Rezoning Petition Review: Charlotte Tree Ordinance

Subject: Rezoning Petition Review – Urban Forestry

Rezoning Petition #: 2021- 033

Date	Description
5/25/2021	First UF review, 2021-05-17 Rezoning Submittal Charlotte Pipe

RZ-1.0

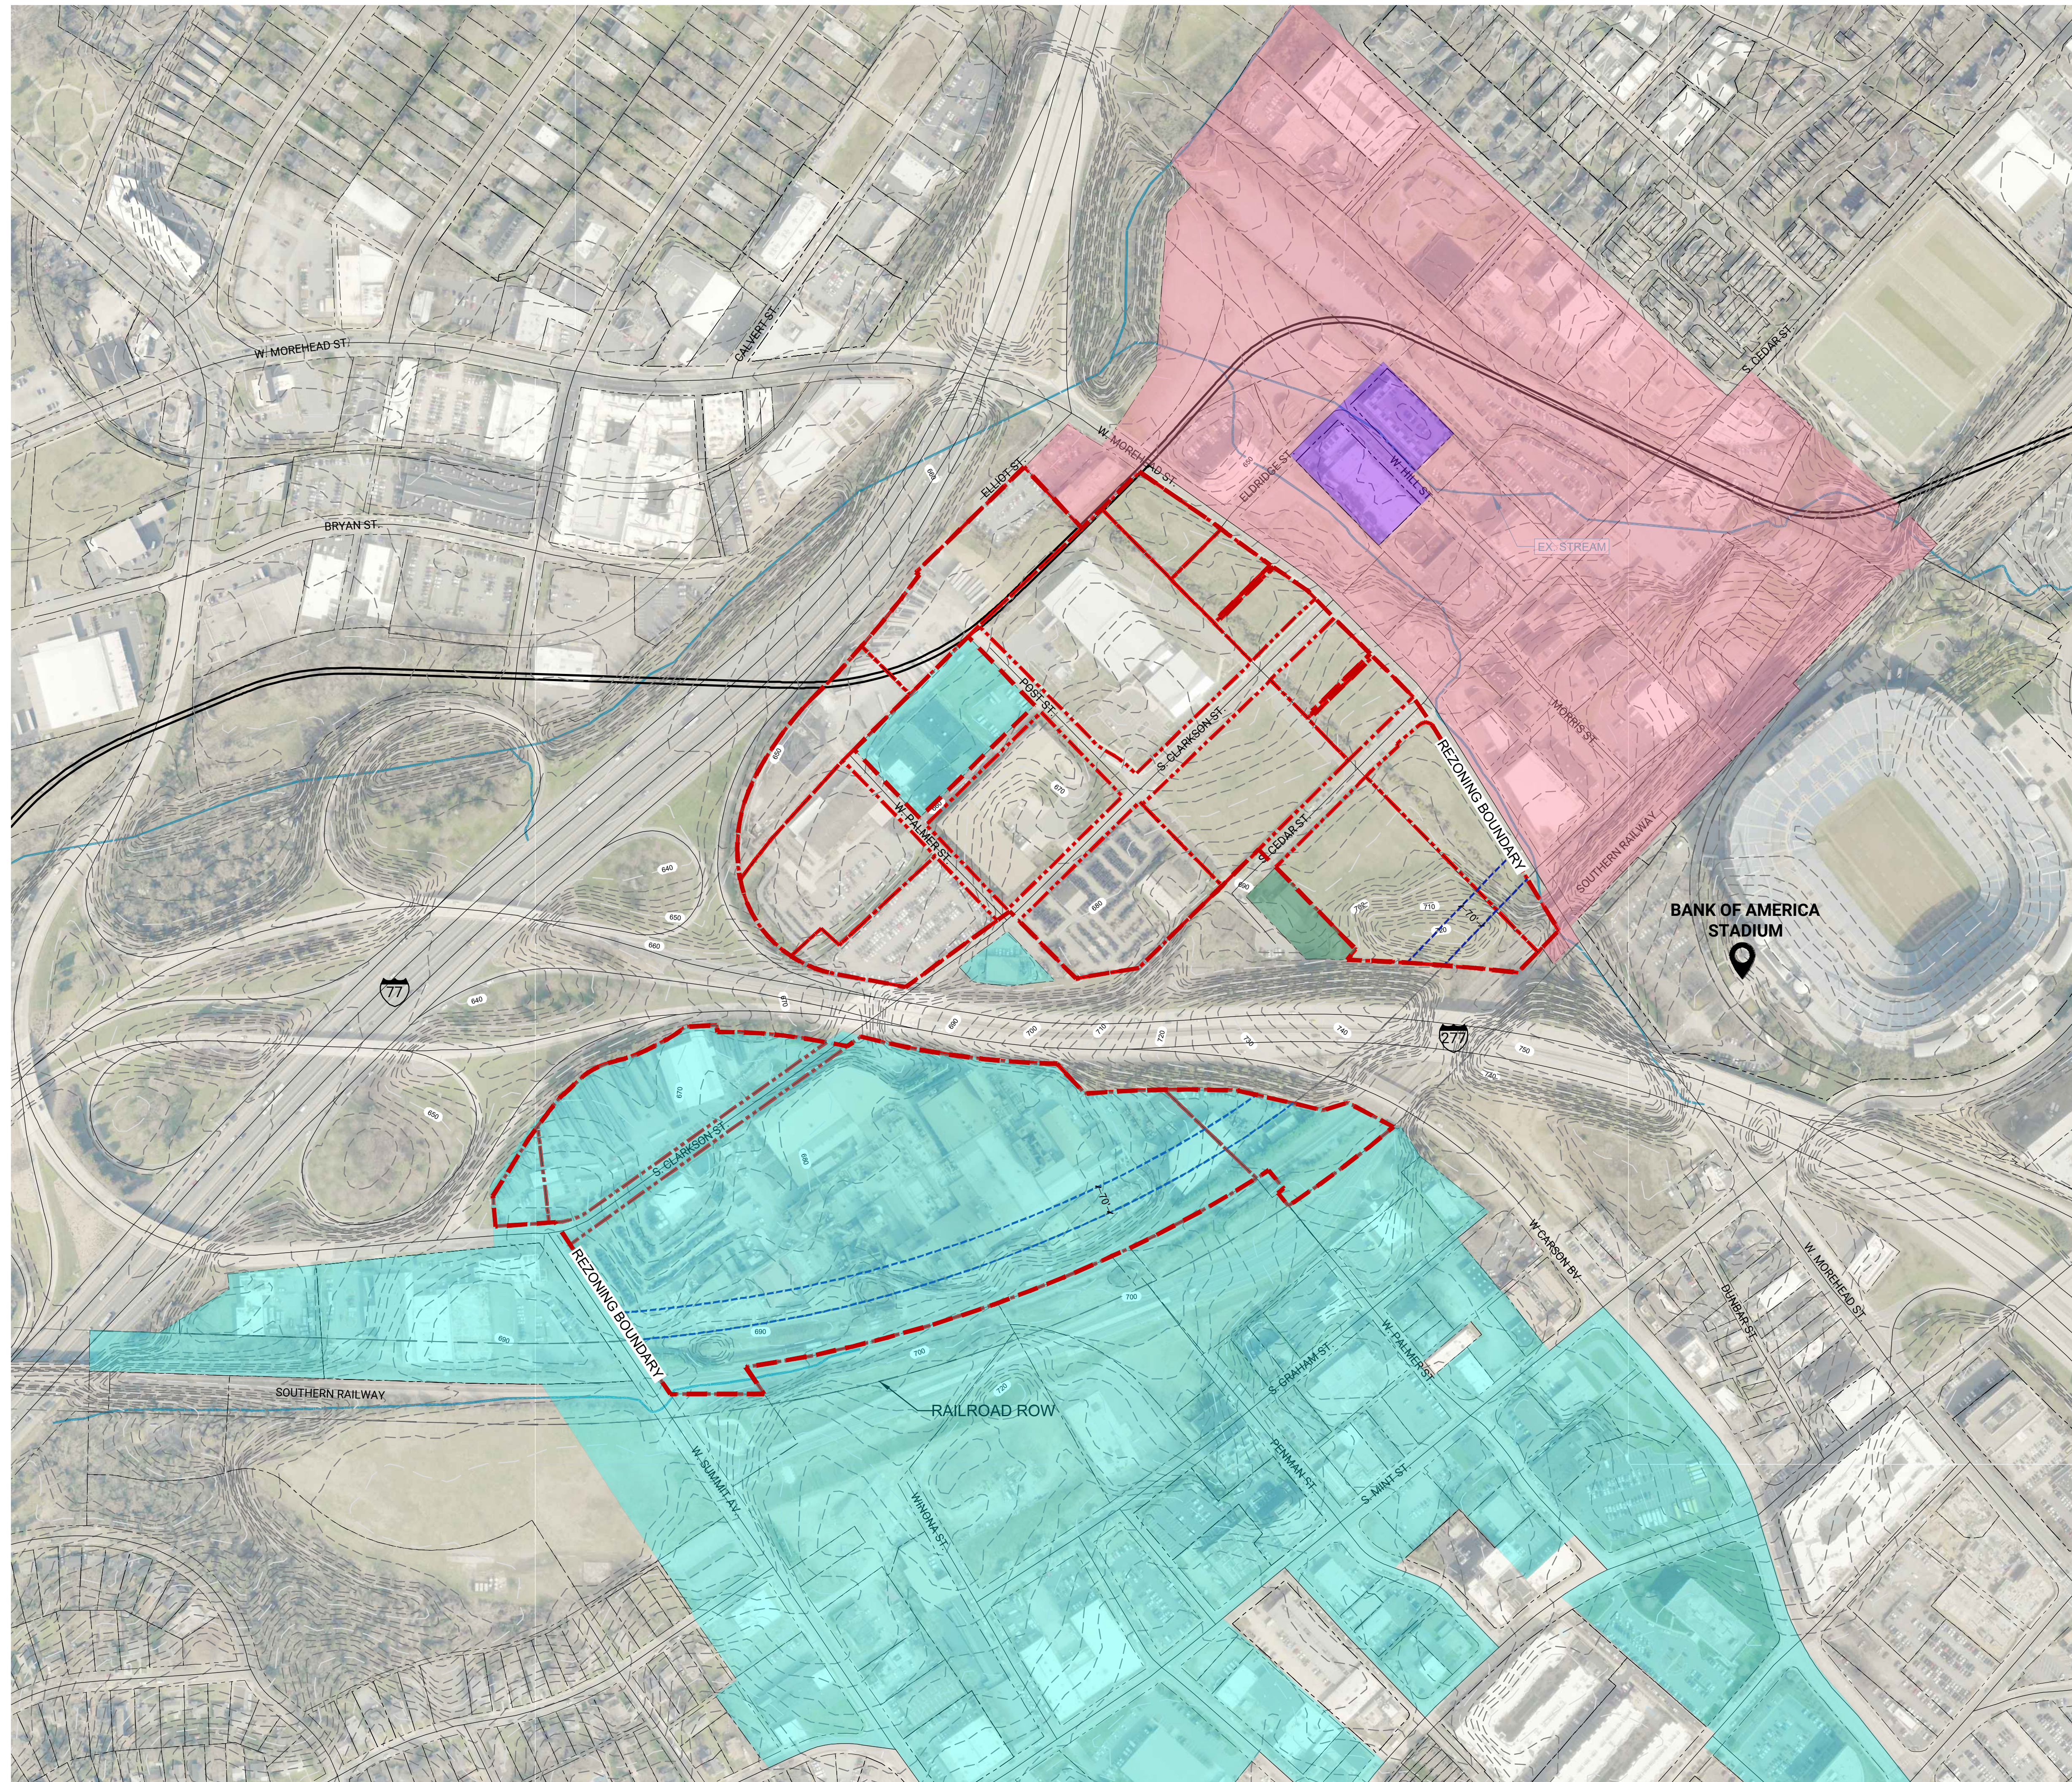
- 1. General** – N/A
- 2. Perimeter Trees** - Perimeter trees must be planted along all public roads within/adjacent to the Site as required per Charlotte Tree Ordinance.
- 3. Internal Trees** – Internal trees must be planted across the Site per standard requirements within the Charlotte Tree Ordinance and may be required to be planted parcel-by-parcel depending on final site design (especially any surface parking).
- 4. Tree Save** – The Site must comply with all applicable tree save requirements.
